From: Simon Davis
Sent: 12 October 2021 15:11
To: Havis, Sean [REDACTED]
Cc: Sparkes, Jessica [REDACTED]
Subject: Drove Lane Sales Cabin refs Y/141/21/PL and Y/142/21/A

Client: Barratt Southern Counties
Site: Ryebank Gate
Job No: Q81095 v4
Date: 24/05/2021
Designer: SM

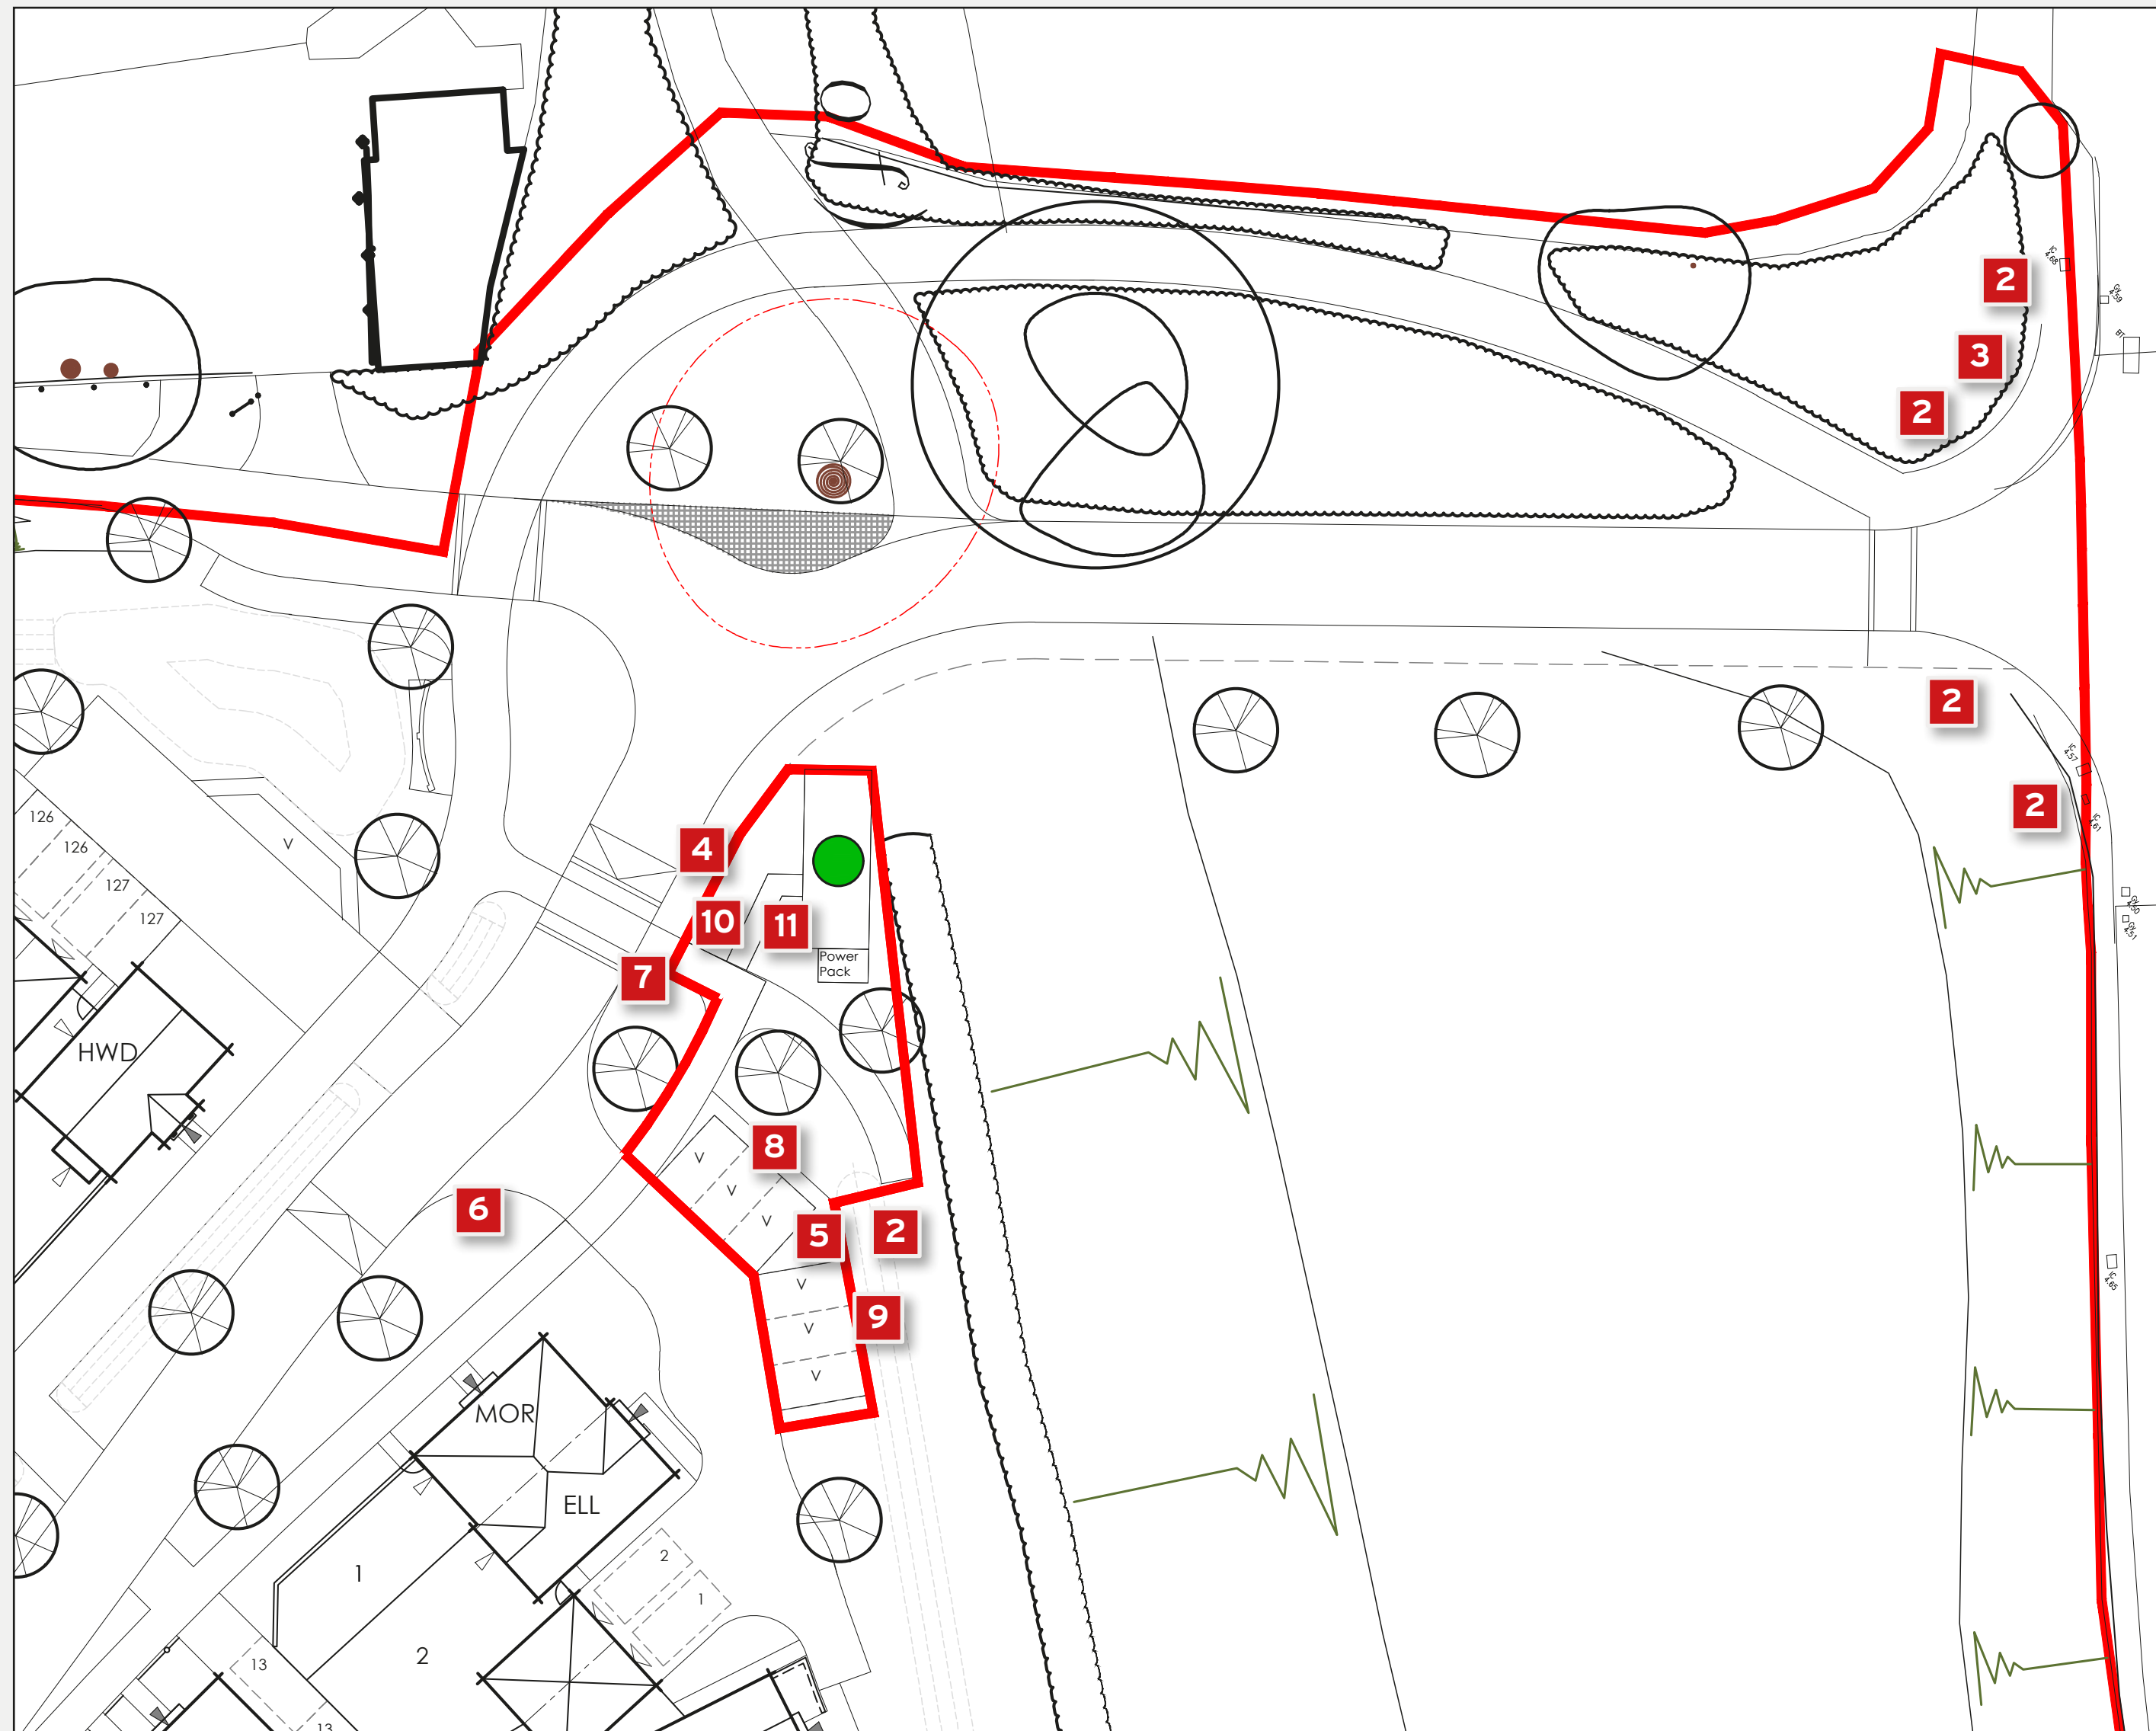
WSCC Highways state that: *"With regards to the proposed advertising the applicant should demonstrate that the totem and static banner flag poles, adjacent to the site access, are located outside of the visibility splays for the main access onto Main Road. If the advertising is located outside of the visibility splay the Highway Authority would not have any objections to the proposals."* Please demonstrate this with a drawing.

Drawing Title:
SALES CABIN
LOCATION PLAN

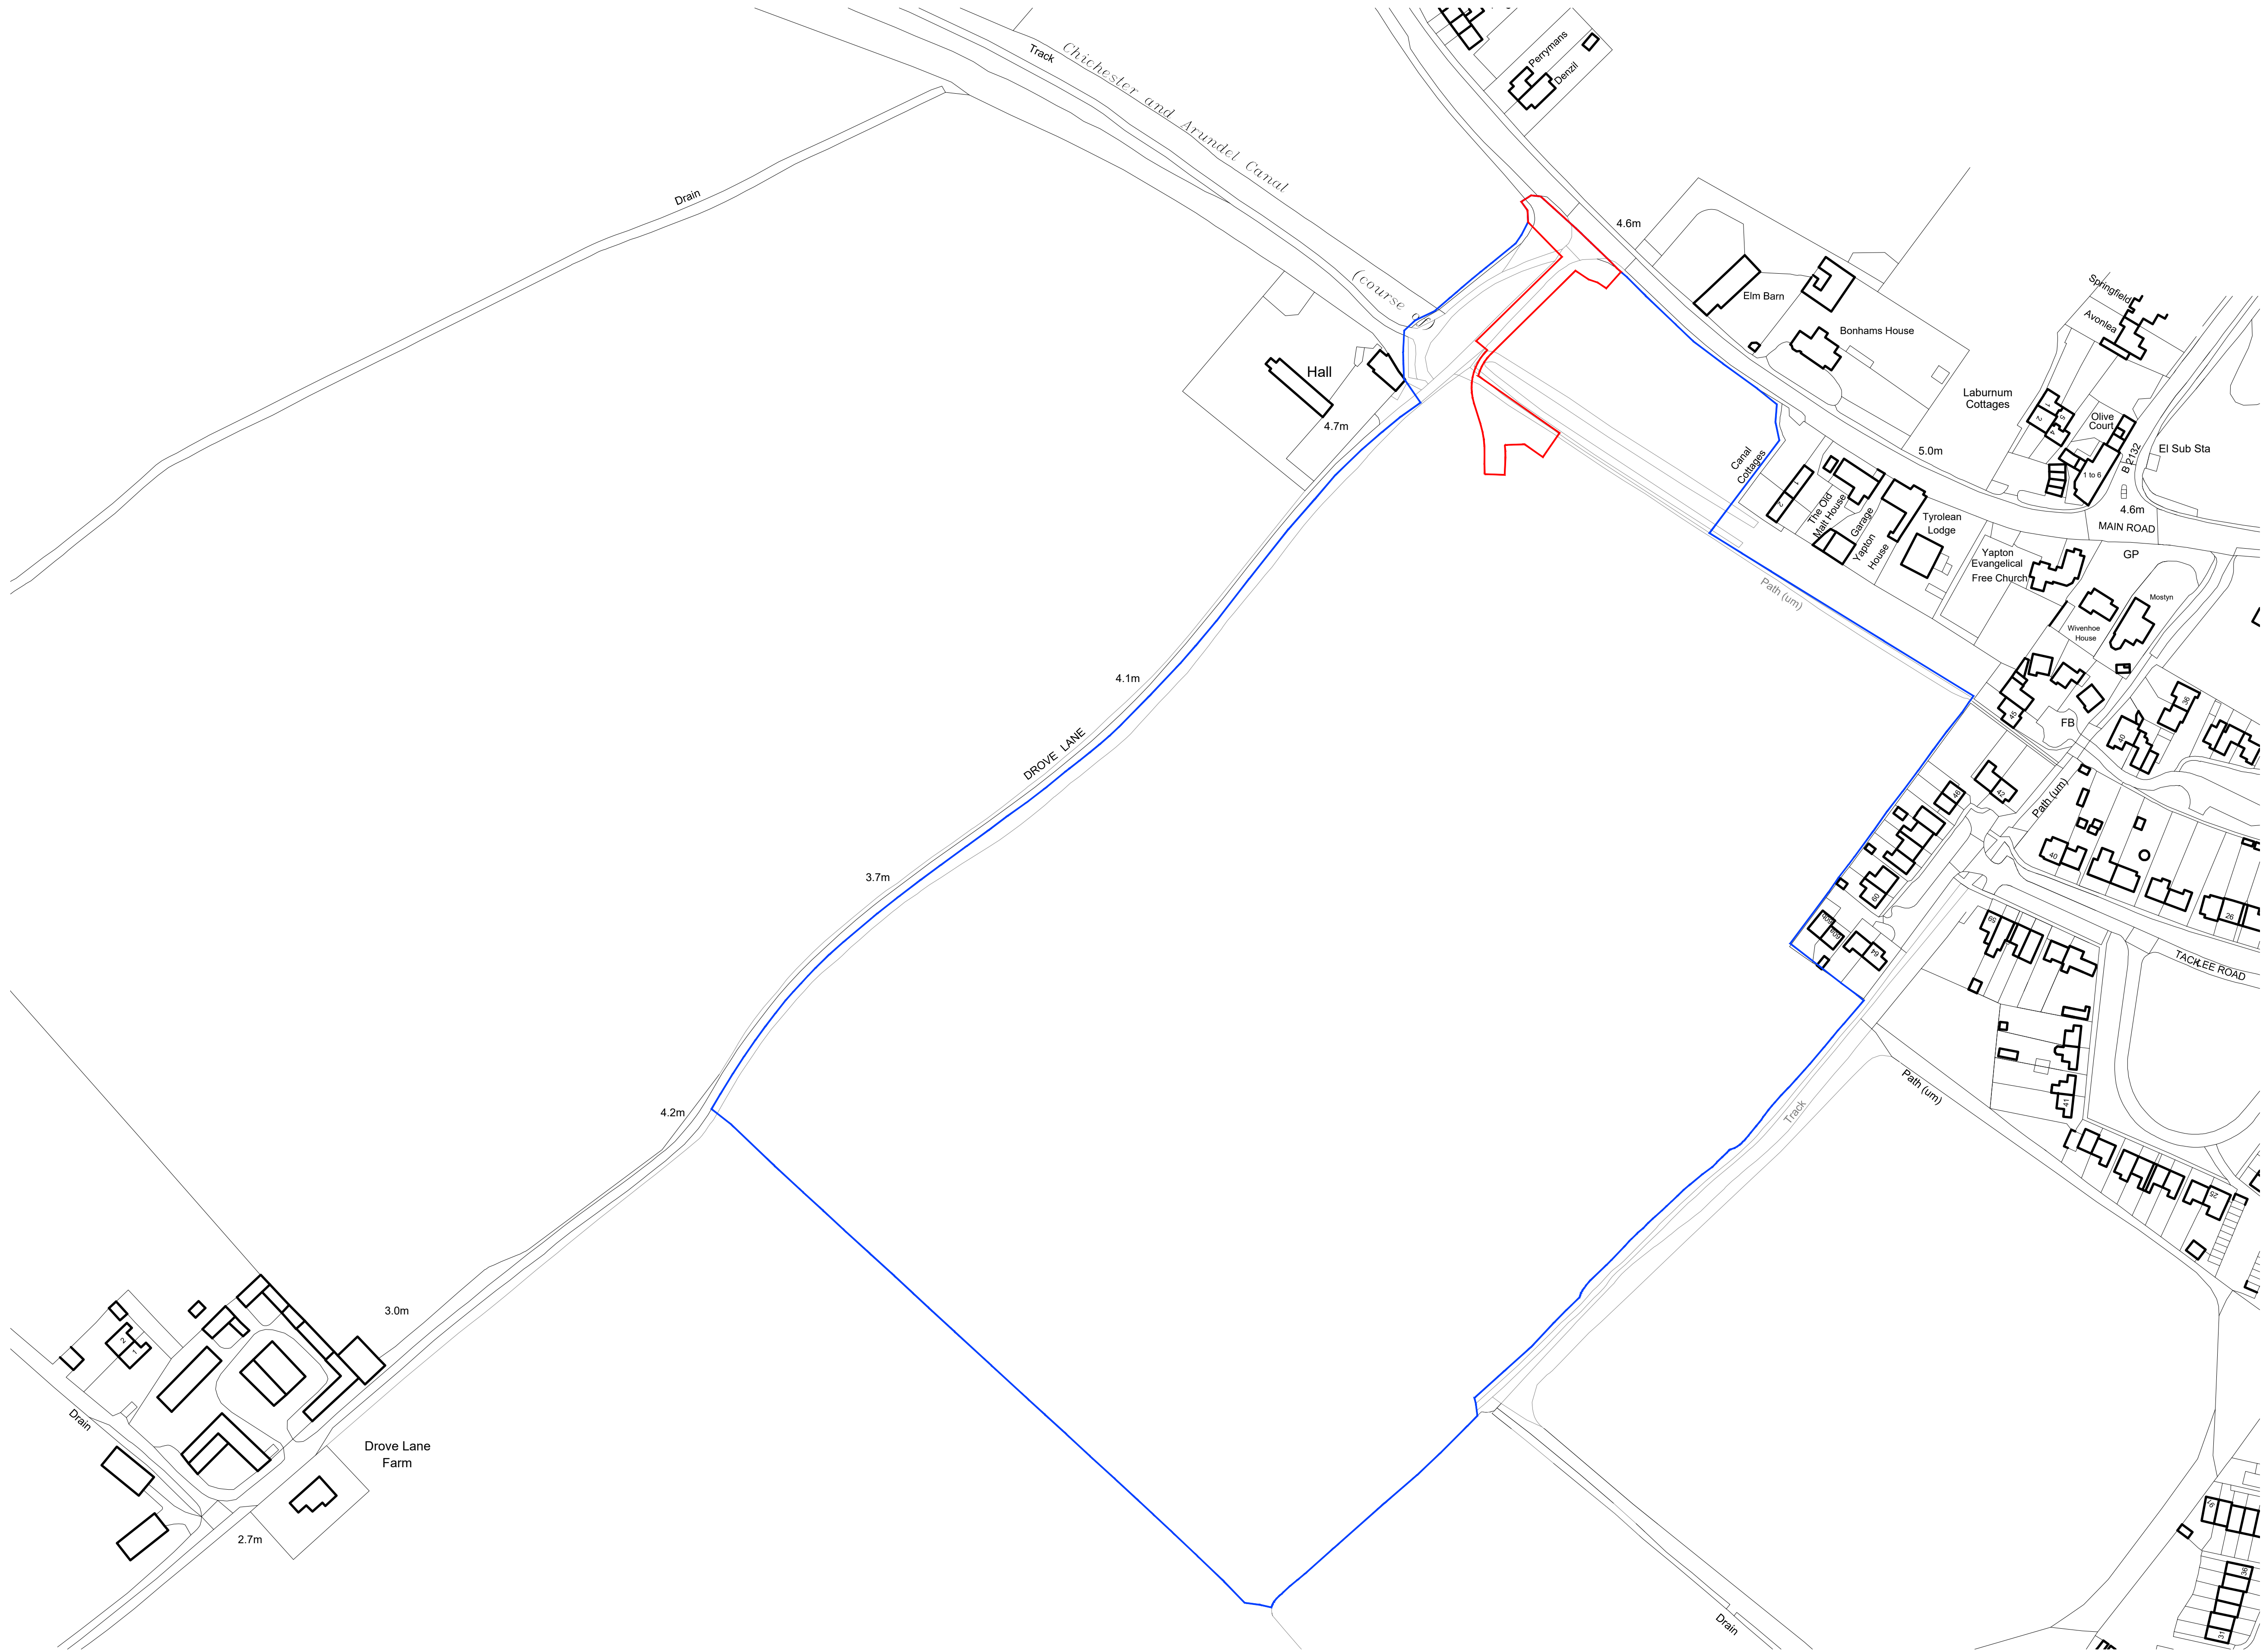
WSCC PRoW state that *"On closer inspection of the Sales Areas (Block Plan) rather than the Location Plan I originally looked at, it is unclear if it is actually sited on FP200_1. Could you please ask the applicant to show the position of the nearby footpaths on a plan so I can see more clearly?"* Please provide a plan.
